**KIRKLEES METROPOLITAN COUNCIL
INVESTMENT & REGENERATION SERVICE**

DELEGATED DECISION TO DETERMINE PLANNING APPLICATIONS

Reference No:	2025/62/91743/E
Site Address:	2, Eleventh Avenue, Hightown, Liversedge, WF15 8LL
Description:	Erection of single storey side extension and associated alterations
Recommending Officer:	Faiza Bano

HOUSEHOLDER DELEGATED REPORT

client	BANE AND BOWEN CHALMERS		
project	PROPOSED EXTENSION 2 ELEVENTH AVENUE LIVERSEDGE WF15 8LL		
drawing	PROPOSED PLANS AND ELEVATIONS		
revision	notes	date	drawn
scale :	1:50 AT A1	06.25	PB
project no.	2428	drawing no.	02

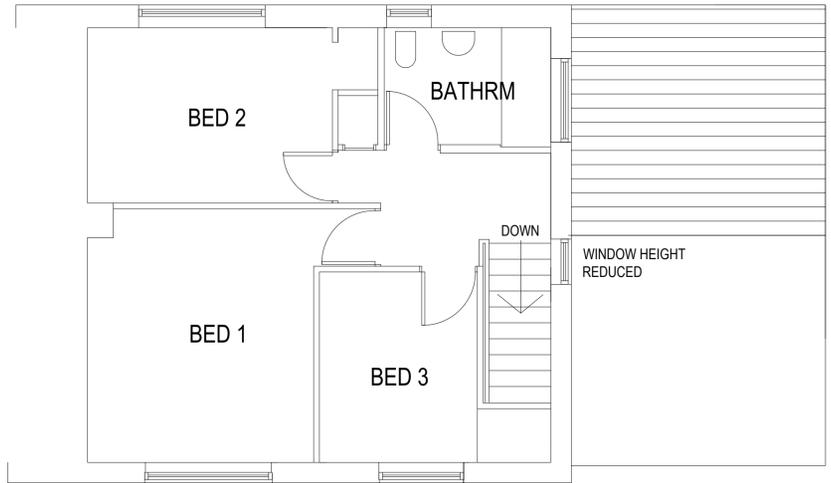
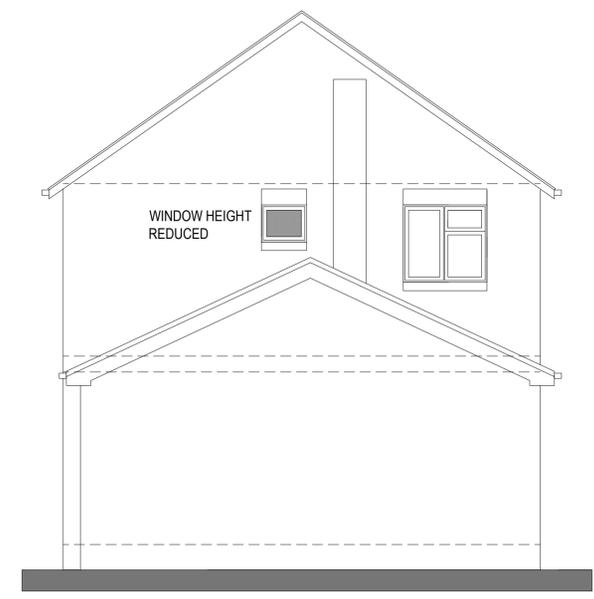
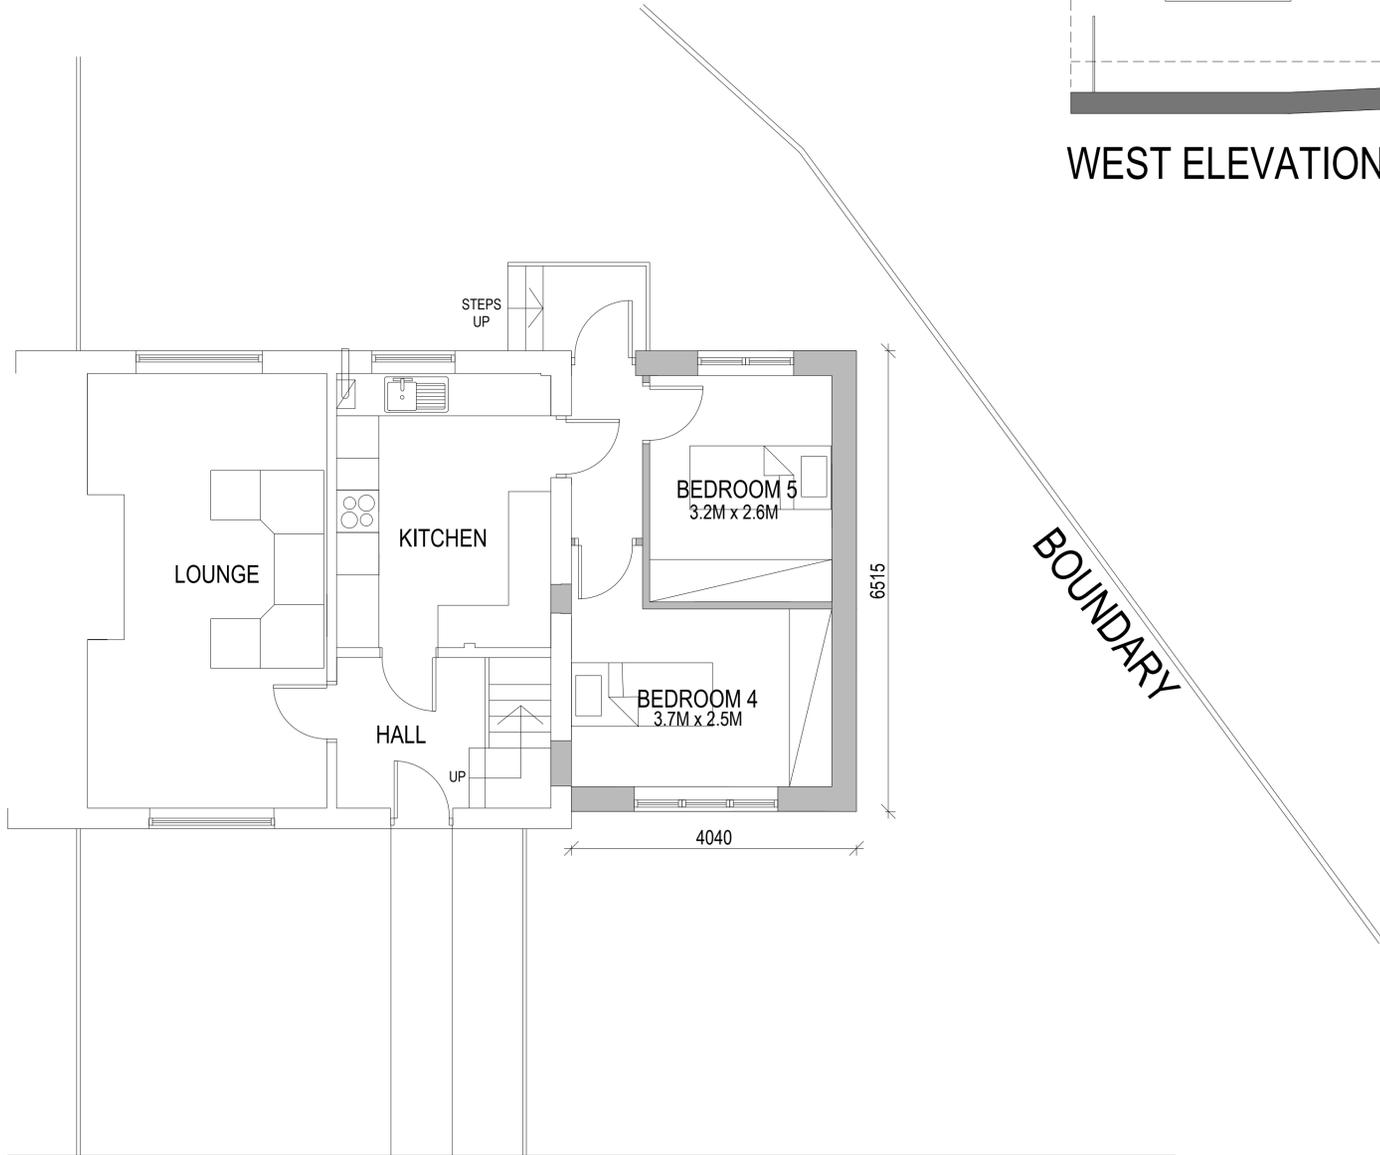
Single storey side extensions should be offset and complement the original building. As such, single storey side extensions should:	<u>Yes - COMPLY</u>	<u>No - JUSTIFY</u>
not extend more than two thirds of the width of the original house;	Yes – the proposal projects out by 4.04m	
not exceed a height of 4 metres; and	Yes – the proposed extension has an eaves height of approximately 2.3m from ground floor level.	
be set back at least 500mm from the original building line to allow for a visual break		The extension is set back by 0.24m which is considered acceptable as there is a clear visual

break and the extension is single storey. It is noted a pd fall back is possible in terms of a side extension with no set back. Whilst such a pd development would require a reduced projection weight is afforded this in the consideration of this application.
--	--	---

The site is prominent in the street due to its location at the junction of the avenue. This will result in the extension being visible from several public vantage points. However, this will be mitigated by the scale of the extension and also the existing side extension to the neighbouring dwelling (number 8).

or street scene across the frontage of the property will be mitigated by the scale of the extension and also the existing of a side extension to the neighbouring at number 8. The design is in keeping with the host property in terms of being a gable roof and will read as a sympathetic addition in this regard, subject to being constructed from matching materials.	
Impact on original house	<ul style="list-style-type: none"> • KDP2 of the SPD • Policy LP24 Design (c) and (d) of the KLP • Chapter 12 of the NPPF 	The original property would remain the dominant feature.	✓
Height, scale and massing	<ul style="list-style-type: none"> • KDP 1 and 2 of the SPD • Policy LP24 Design (a), (c) and (d) of the KLP • Chapter 12 of the NPPF 	As above. The extension would project across the side of the property and is single storey.	✓
Facing materials and detailing	<ul style="list-style-type: none"> • KDP 9 of the SPD • Policy LP24 Design (d) (iii) of the KLP • Chapter 12 of the NPPF 	Facing materials to match existing.	✓

Roof style	<ul style="list-style-type: none"> • KDP 1 and 2 of the SPD • Policy LP24 Design (a), (c) and (d) of the KLP • Chapter 12 of the NPPF 	Pitched roof style on the side extension – acceptable as it is in-keeping with the original roof style of the host property.	✓

Window proportions	<ul style="list-style-type: none"> • KDP 1 and 2 of the SPD • Policy LP24 Design (a), (c) and (d) of the KLP • Chapter 12 of the NPPF 	Modest size windows in extension, which would be in-keeping with existing building.	✓
Accessibility for all users	<ul style="list-style-type: none"> • KDP 17 of the SPD • Policy LP24 Design (f) • Chapter 12 of the NPPF 	Private domestic extension which would provide easy access into the main house.	✓

- 8 Third Avenue – the single storey side extension will not overshadow this property or its garden space. Due to the height/scale, there will be no significant impact on the first floor. There is considered to be a limited impact to number 8 with the extension designed to ensure privacy to neighbours is maintained and the proposal will not significantly impact upon light and outlook.

<ul style="list-style-type: none"> • Policy LP22 Parking (f) of the KLP • Chapter 12 of the NPPF 		
Provision for waste storage	<ul style="list-style-type: none"> • KDP 16 of the SPD • Policy LP24 Design (d) (iv) • Chapter 12 of the NPPF 	None shown on plans however, there is sufficient space within the red line boundary to allow for storage on site. Condition not considered necessary.	✓

3. The external walls and roofing materials of the extension hereby approved shall in all respects match those used in the construction of the existing building and be retained thereafter.
